The applicant has explained a foot path is included, within his application, in connection with Dartmouth Estate.

The image below, taken from one of the applicant's submissions, shows the path in question; running north of a proposed row of hedges.

SITE AT LINGARDS ROAD - PROPOSED HOUSING			
CLIENT - S.B. HOMES LIMITED			
William Best RIBA		SITE SECTIONS A, B, C	
The Chapel House, 22, Pole Gate, Scammonden, West Yorkshire, HD3 3FW. Tel 01484 845896 Mob 07828 461144		SCALE	DATE
		1:200 WB	17/01/2020
		2019-572-13 G

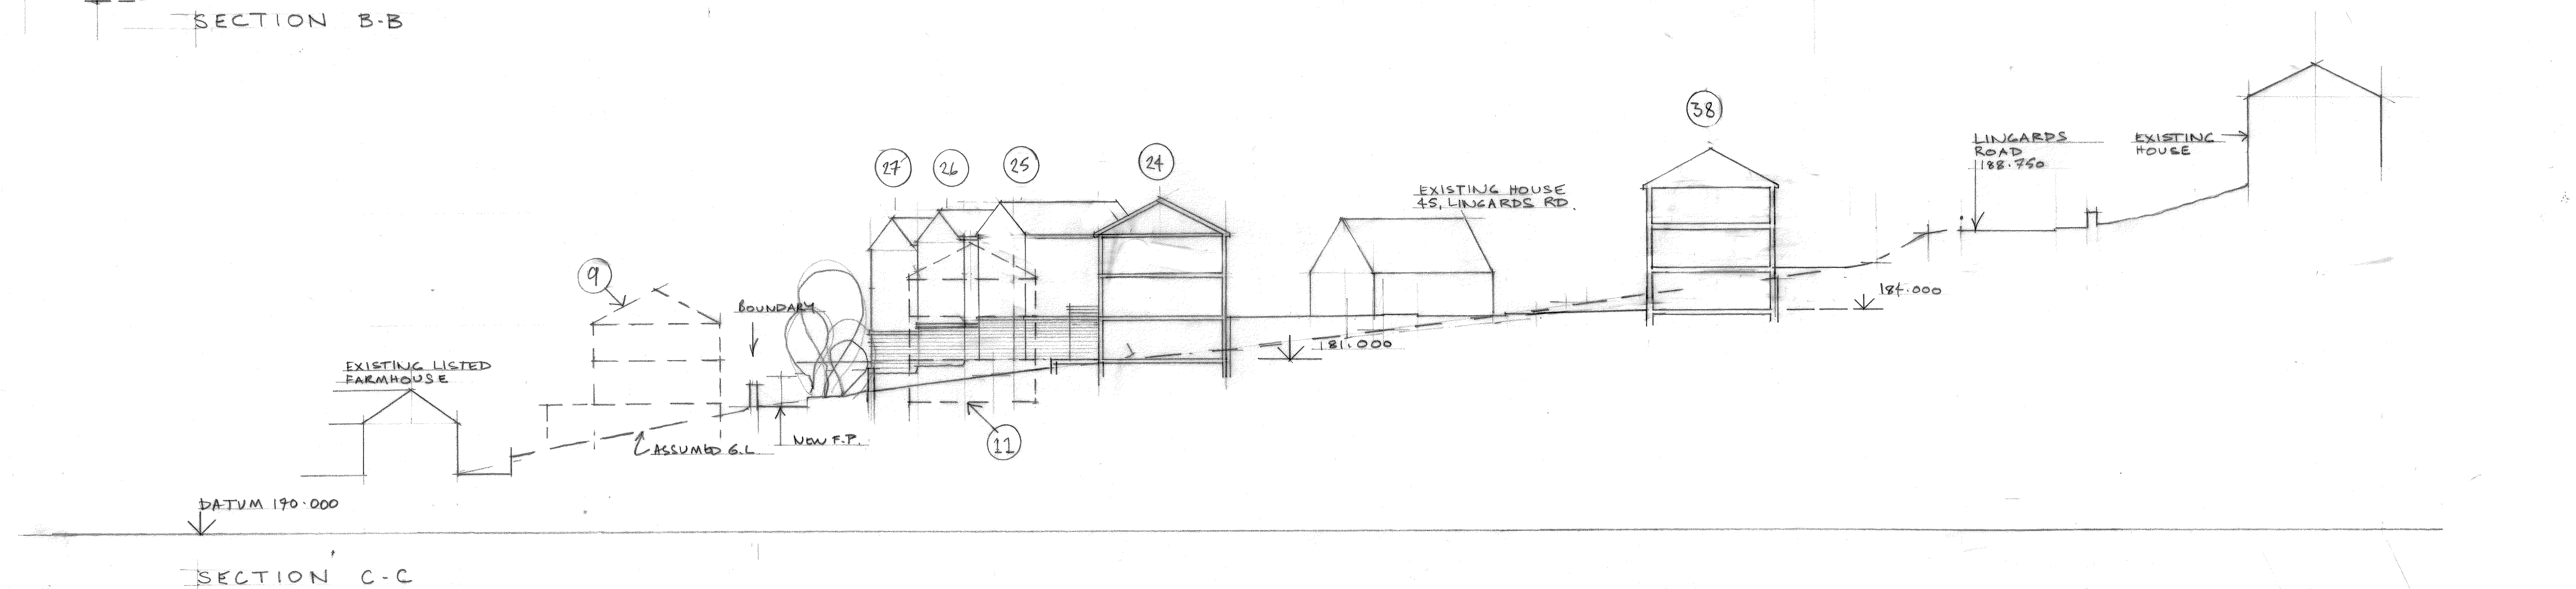
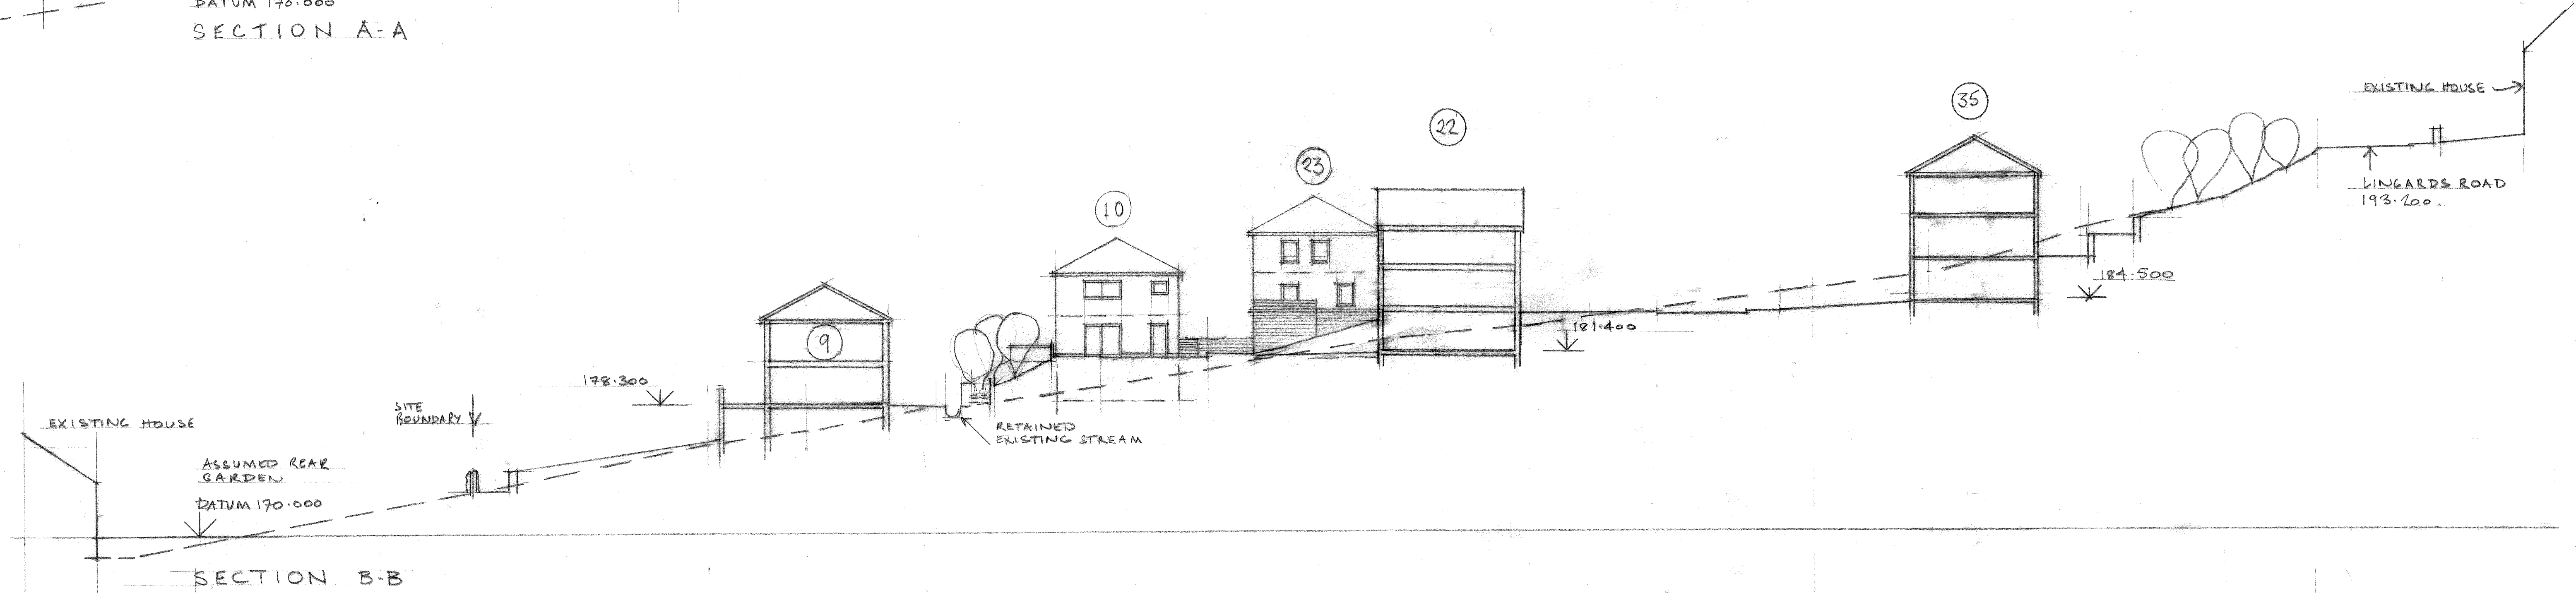
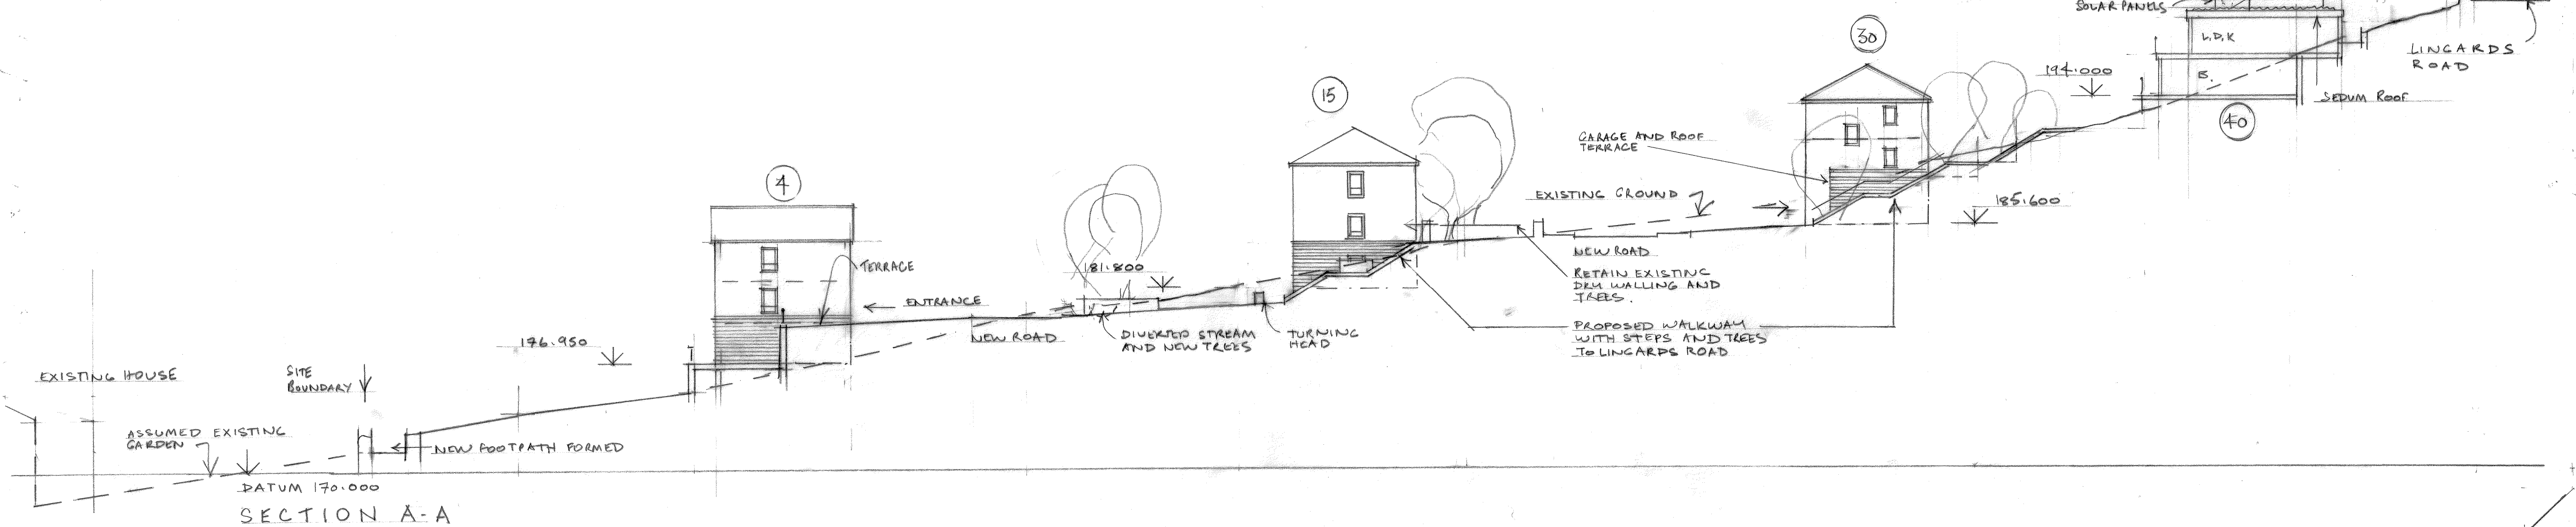
The path borders the Dartmouth Estate land that is currently rented by Manchester Road residents.

The path appears as being elevated, circa 2.4m above the height of the rented land.

As such, this seems inordinately high.

I'm sure existing neighbours would find it quite overbearing and question it needing to be so high.

It would seem, to me, to be far more appropriate to have the path at the same height as the rented land.

Surely, this design cannot be considered good.

If, on the other hand, the path is meant to be lower (for example, at the same elevation as the rented land), it spotlights another of the many issues with this application; namely the contradictions and inaccuracies that have been found and commented on.
